Harnett County
420 McKinney Pkwy
LILLINGTON, NC 27546
Phone:
Fax:

8/15/2022

SUBJECT: SFD2111-0015
SINGLE FAMILY DWELLING

Here are the results of all Inspections located at **1393 WALKER RD:**

FOUNDATION PLAN
SCALE: 1/4" = 1'-0"

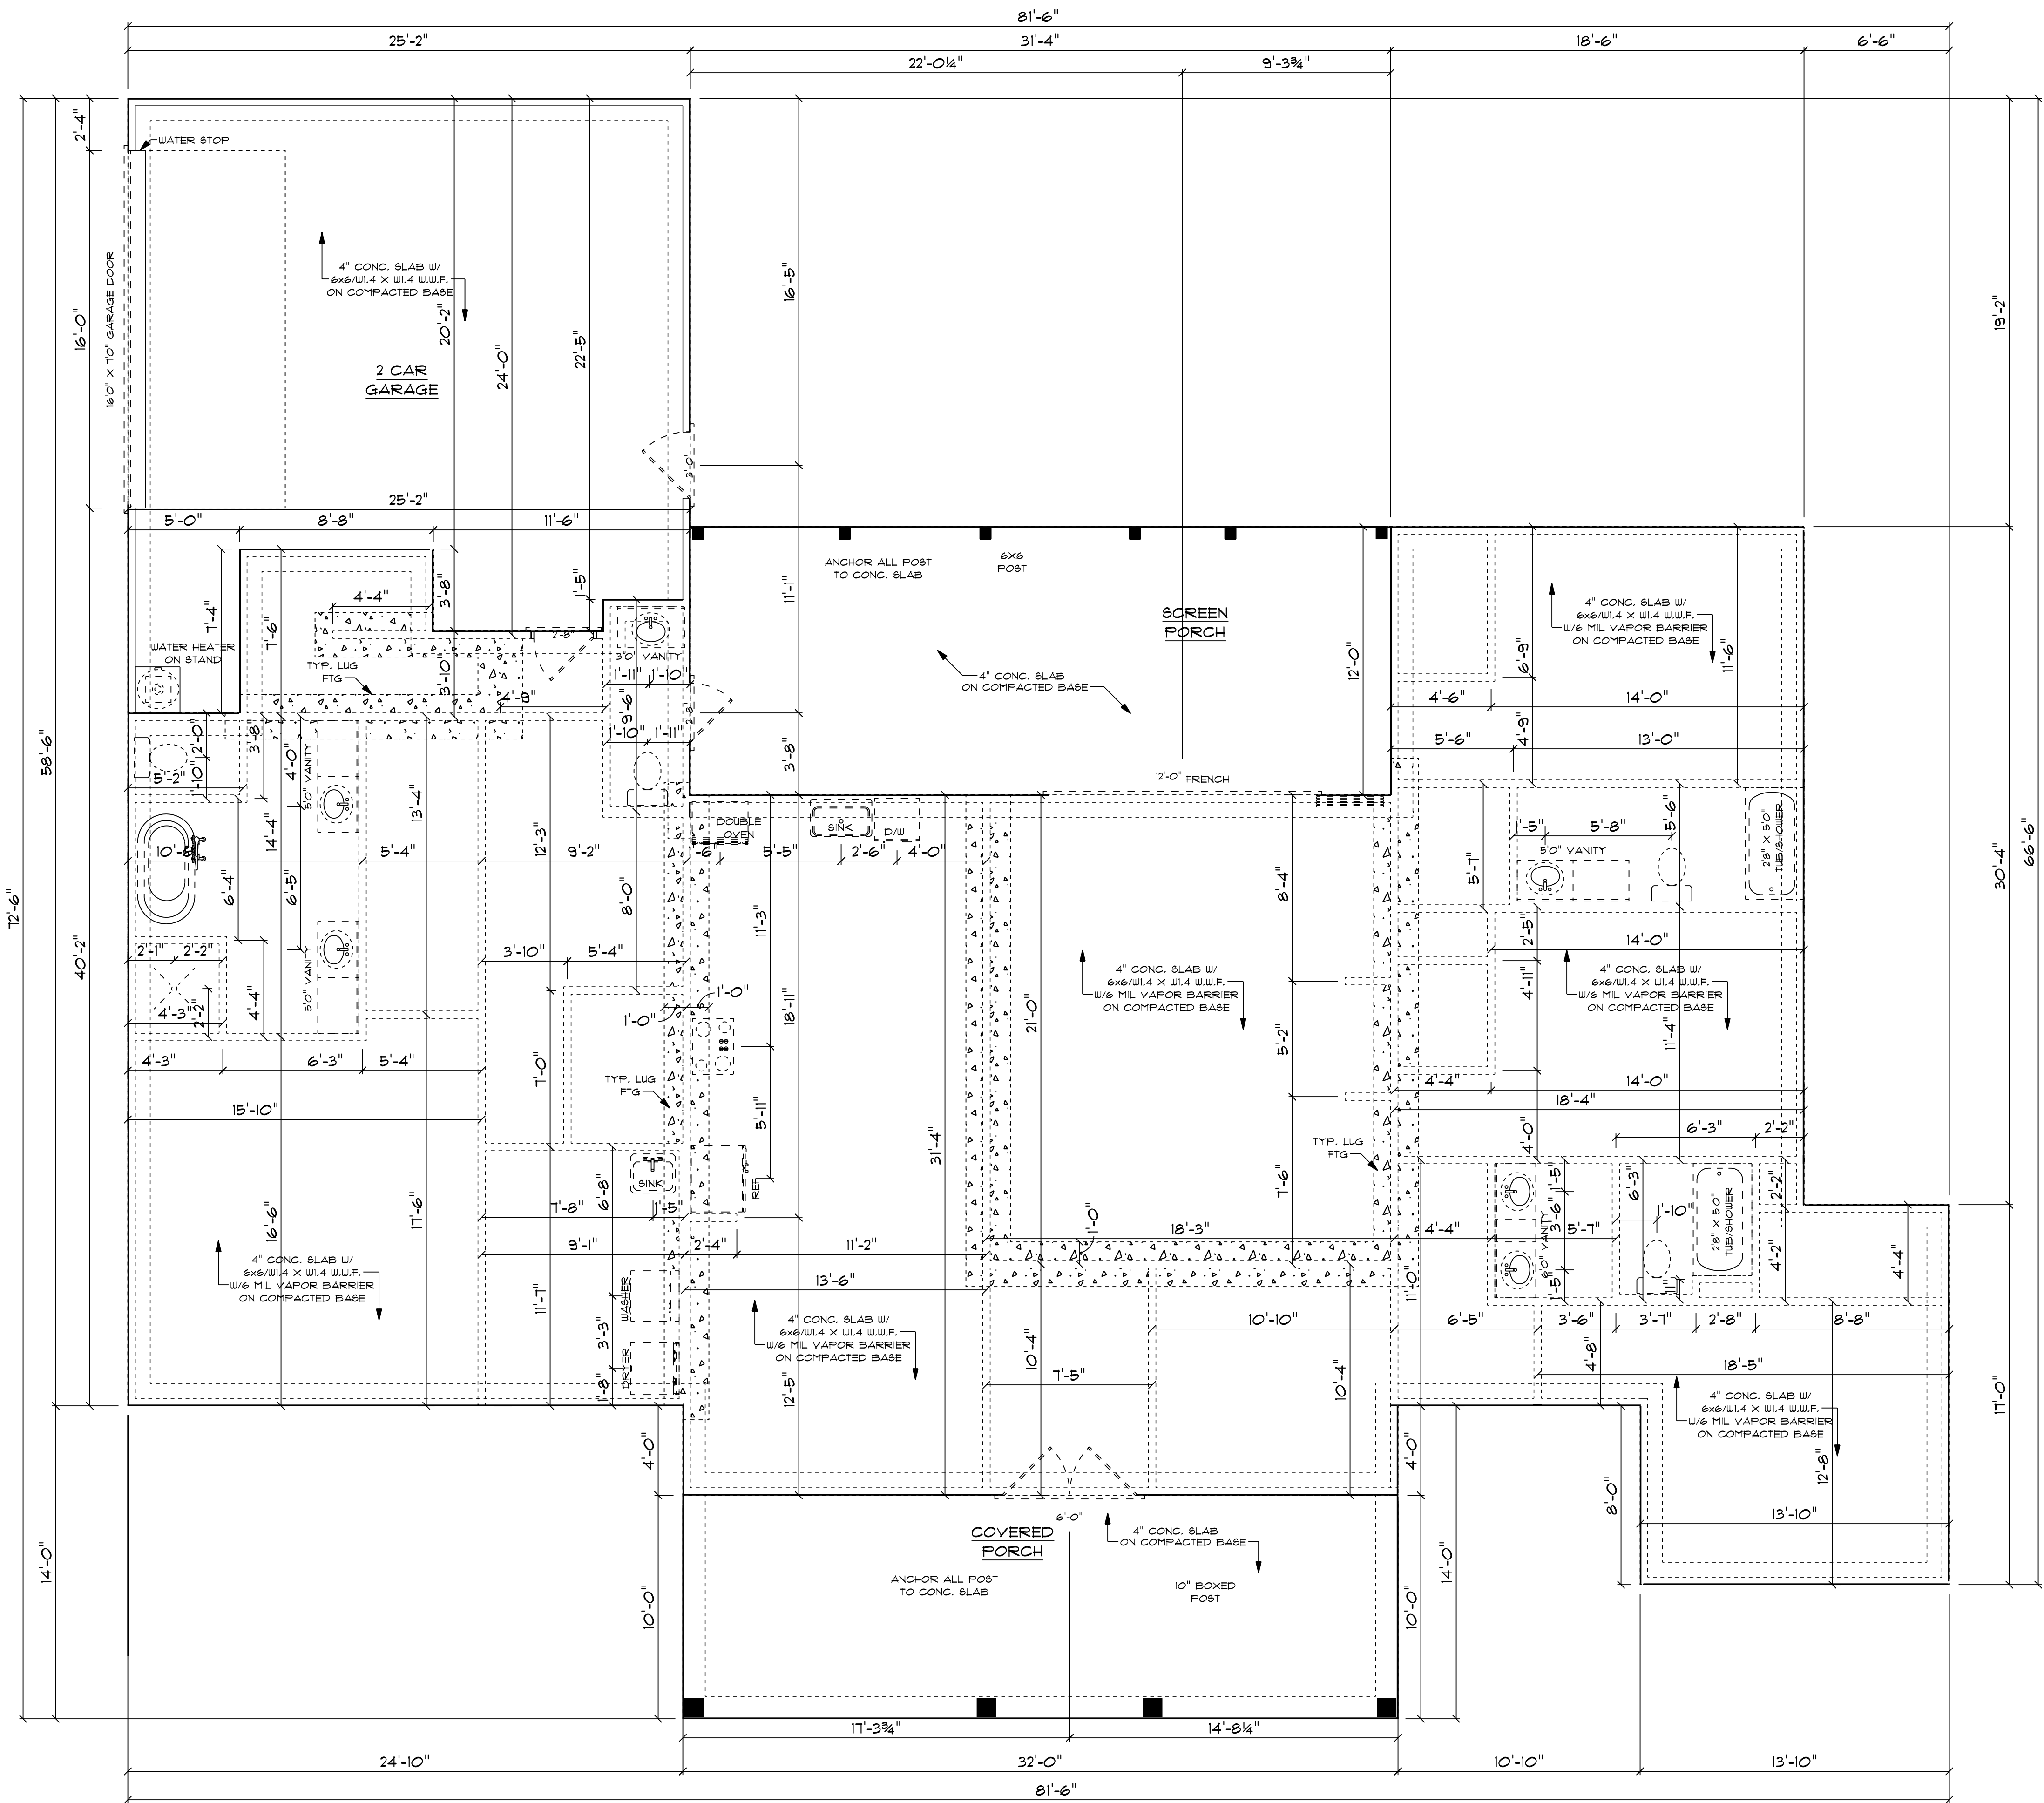
Notes: 1.Nail all lvl beams every 12" & 3 ply lvl beams from each side per documents. 2.Nail all 2 & 3 ply roof trusses per truss documents & attach the correct hurricane straps. 3.Missing anchor bolts in garage in many places per code. 4.Missing nail guard @ bottom plate on 3" pipe in garage @ stairs. 5.Block between ceiling joist in garage @ chase in ceiling. 6.Missing nails & bolts in 4 ply roof truss in garage per truss documents & needs more hurricane straps. 7.Fire caulk red water line @ top plate to right of refrig in garage. 8.Nail guard on water line @ top plate over sink in half bath. 9.Fasten all toilet flanges per code. 10. Anchor bolt each side of exterior door in half bath. 11. Anchor all interior load bearing walls per code. 12. Fire caulk termite tubes @ top plate to right of window in master bedroom. 13.Fill hole in floor in master bed @ end of shower. 14.Missing tub in master bath & fill hole under tub. 15.Need 2 king studs each end on window in master bath. 16.Seal all holes under knee walls in master bed & laundry room. 17.Fire caulk red water line in top plate in laundry room. STOP @ LAUNDRY room
